**From:** Sarah Fletcher <fletchsa1@gmail.com>  
**Sent:** Thursday, March 16, 2023 6:56 PM  
**To:** Ryan Harriman  
**Cc:** Suzanne Skone; Dan Thompson; Mike or Susie Cero; Carv Zwingle; Thomas Acker; Council; Traci Granbois; Robert Medved; Jessi Bon  
**Subject:** Re: Public Comments SUB 19-002/Boys and Girls Club Long Subdivision

2/16/23
 JOB NUMBER:
13-118
 SHEET NAME:
SP-01
 SHT **3** OF **9**

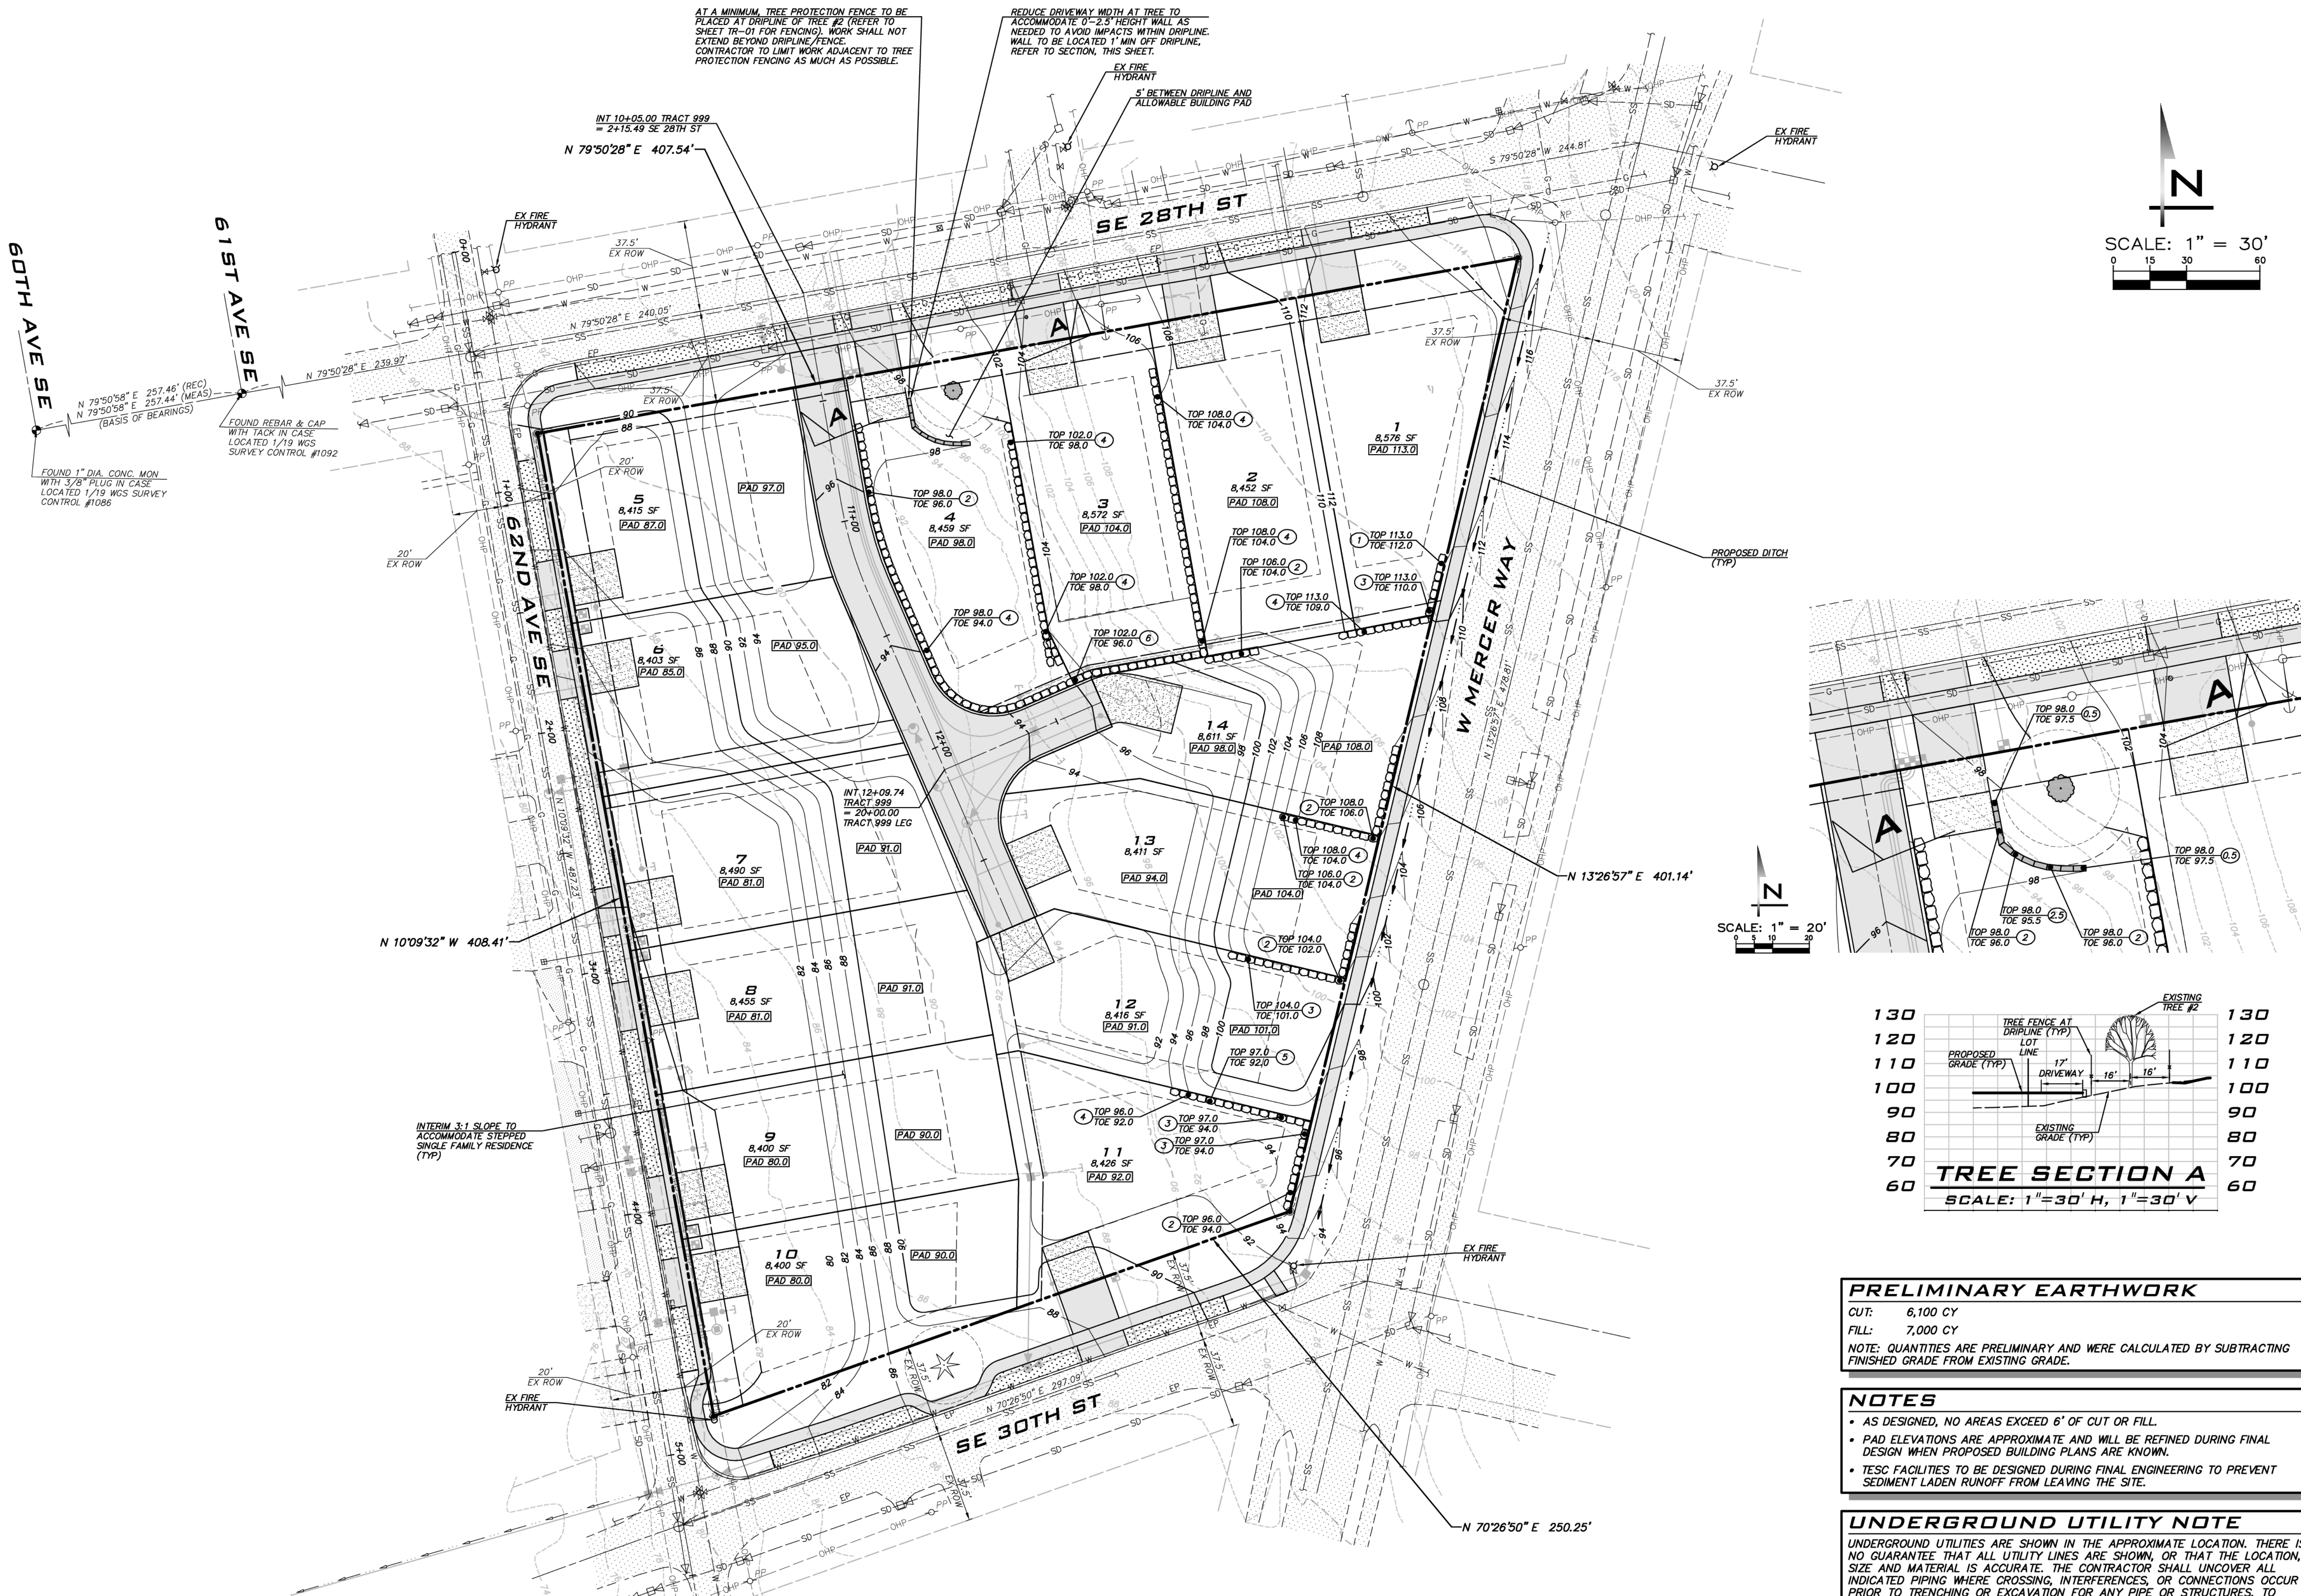
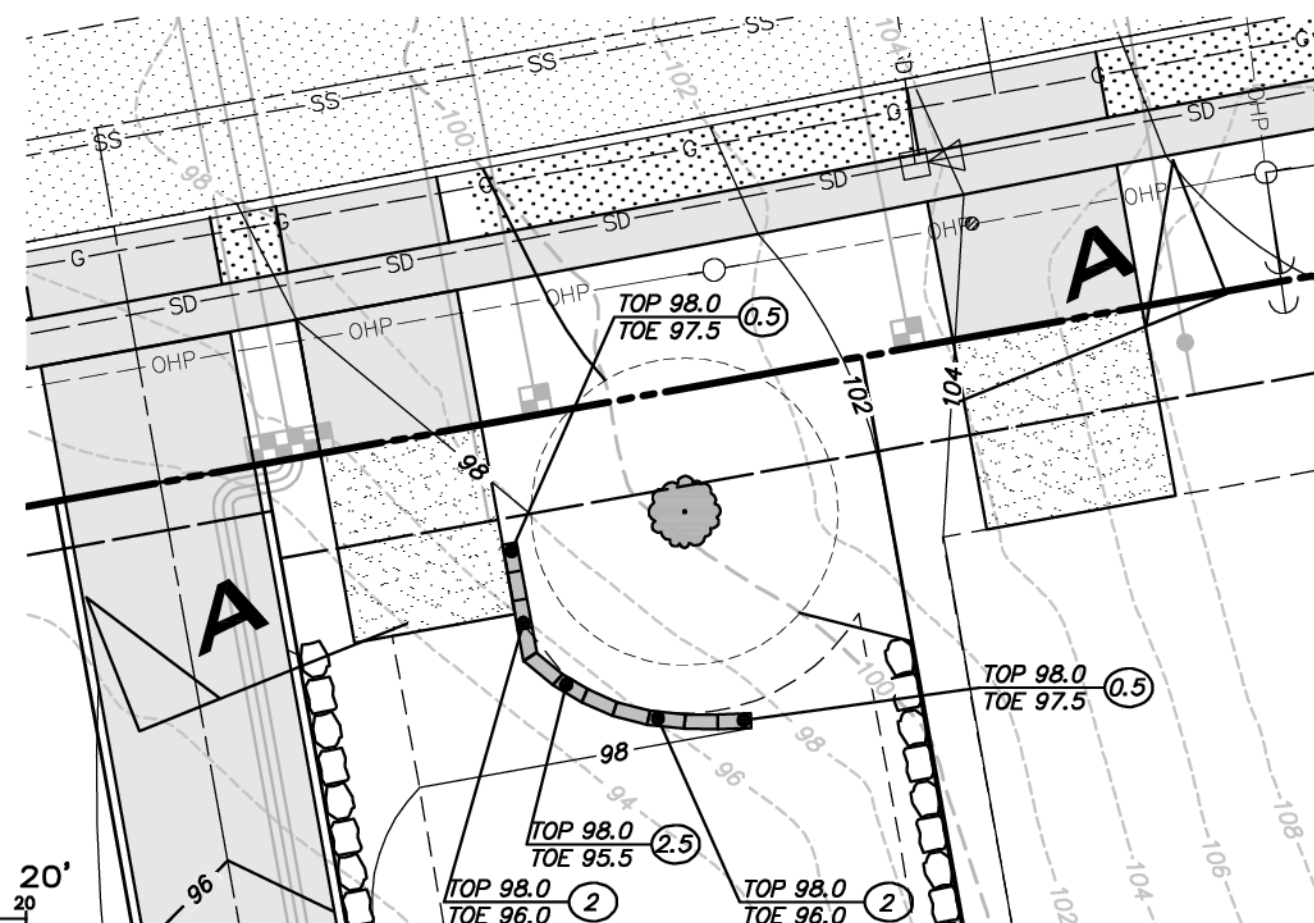
A. There is no green space at all, despite the demolition of an historical building and removal of many mature trees. I believe some green space setaside should be required as in the original plans although it reduced the total number of lots from 14 to 13.

B. Ingress and egress should be by internal road for each house. The applicant no doubt does not like this since the internal road counts against lot area and lot coverage limits, but in my opinion the current plans are a danger to those walking or biking along adjacent streets. There is some internal access to some lots, but all access should be by an internal access road.

My belief is the MICC requires the applicant to set aside an area equal to one lot for green space, and all access should be by internal roads. These are the same findings Evan Maxim made if you review his file, and were the findings of the council in the Coval long plat process.
